**SUBJECT: SFD2107-0065  
SINGLE FAMILY DWELLING**

Here are the results of all Inspections located at **200 GILCHRIST RD:**

CONCRETE BLOCK PIER DETAIL  
NOT TO SCALE

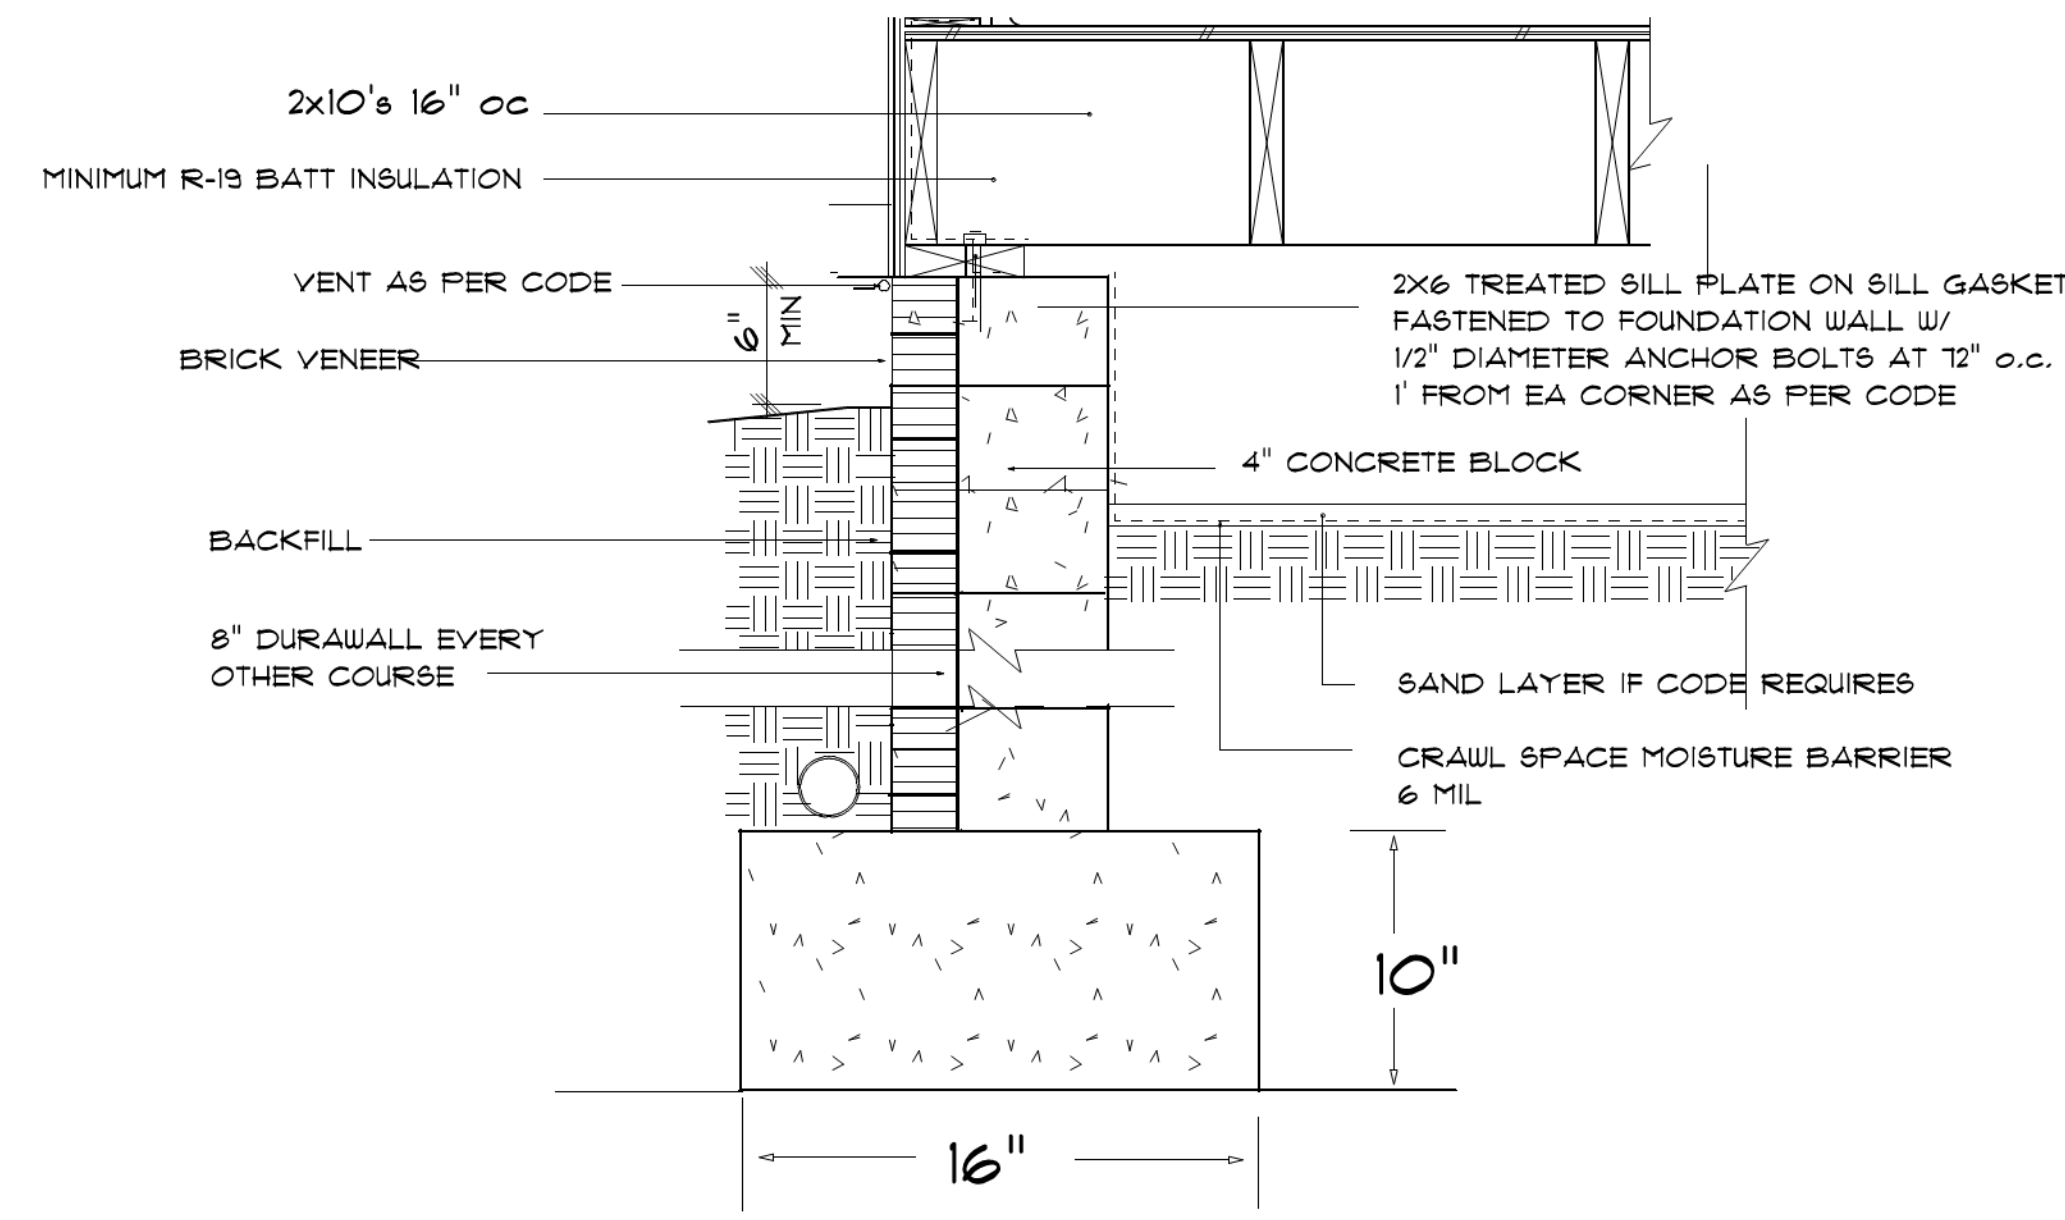
Missing roofing/flashings. Missing doors and windows. Porches not flashed. Missing roof boots missing tie backs on rafters. Shower pan liner not installed. Kitchen outlets not roughed in. Missing mid story strap and nail plate on hvac line set. Garage door opening must comply with portal frame detail. Plumbing drain test down. Showers not framed. Missing insulation and air barrier behind tub. Missing insulation baffles. Missing hangers or ledger strips on exiling joists. Missing lvl sheets. Provide engineering letter on sticker framed roof lvl's to ridge connections. Outlets missing wiring in office. Not all wiring pulled into panel. Wiring not secured. Draft stop top off office wall. Seal all plate penetrations. Girders must fully bear on piers. Missing double joists. Rear deck not finished with framing.

FOUNDATION PLAN  
SCALE: 1/4"

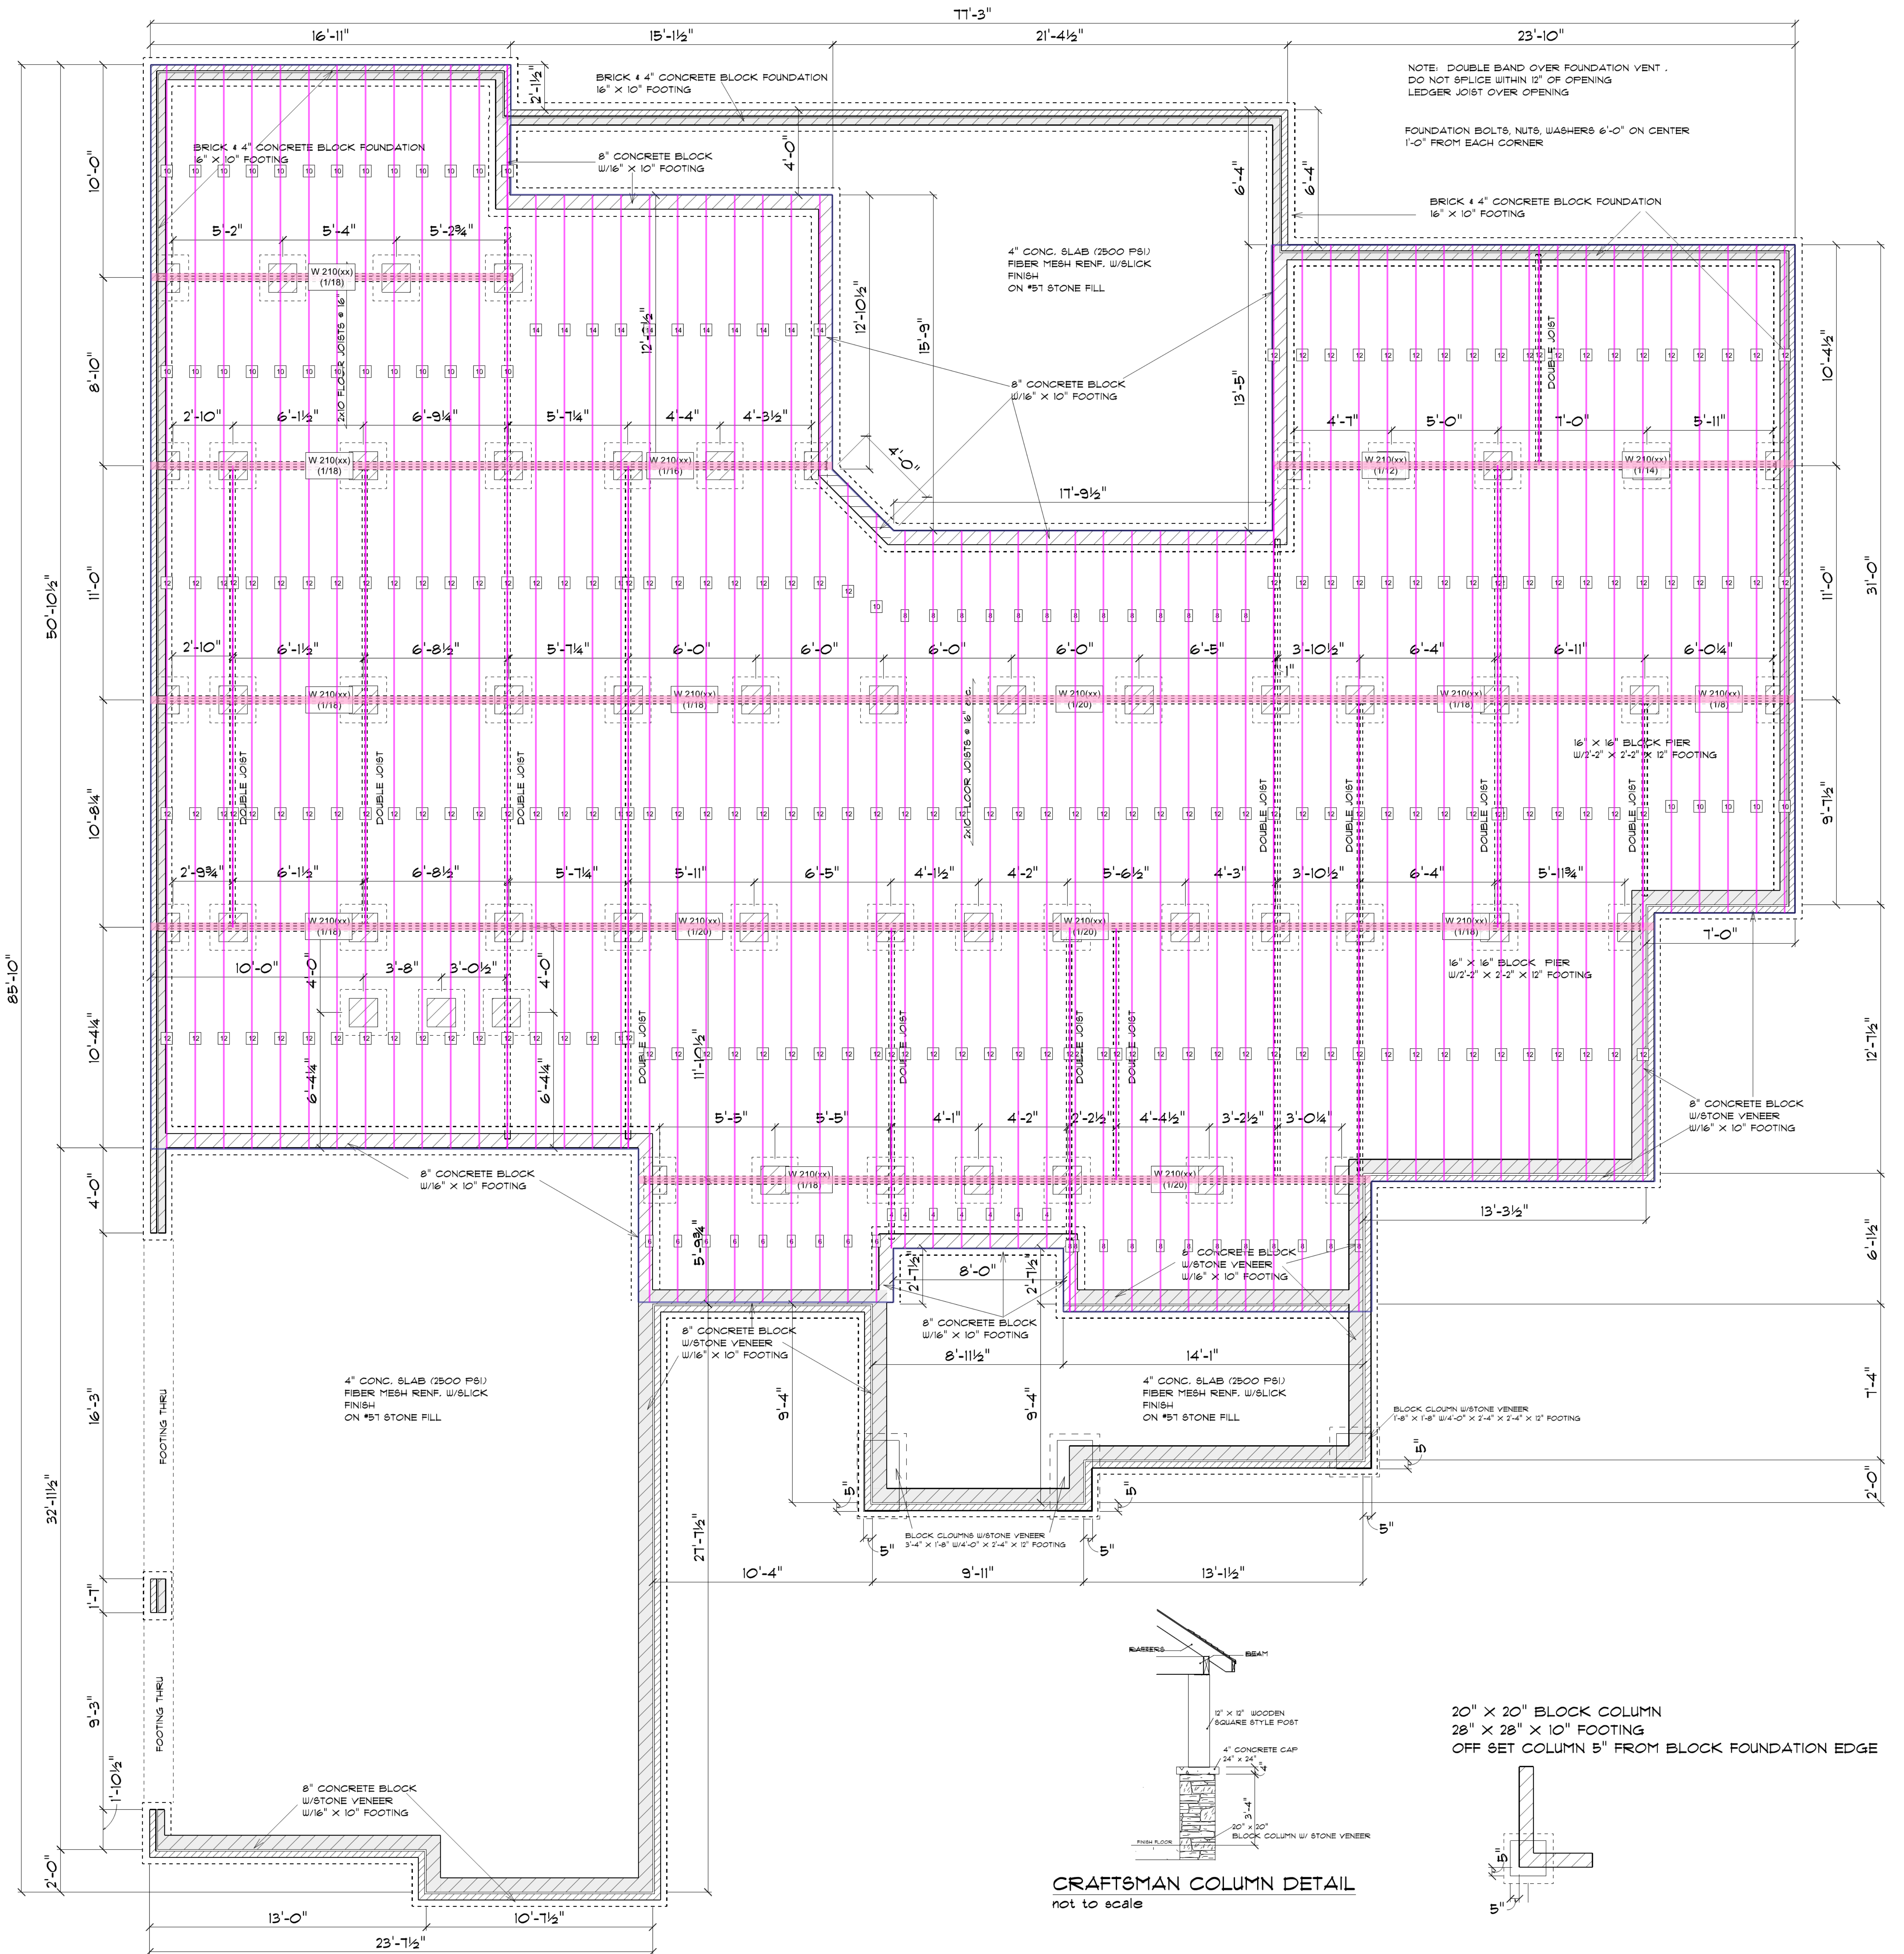
Must have plan reviewed plans onsite with plan review stamp. Several piers do not meet minimum projection, provide engineering. Clean top of footers to allow for inspection of bed joints. Missing foundation damp proofing.

Inspection Type: FOUNDATION  
Scheduled Date/Time: 11/18/2021  
Completed Date/Time: 11/18/2021  
Inspector: Steven Gazlay  
Result: APPROVED W/EXC  
Remarks: eTRAKiT Inspection Request  
Notes: eng letter in file  
Missing foundation damp proofing.
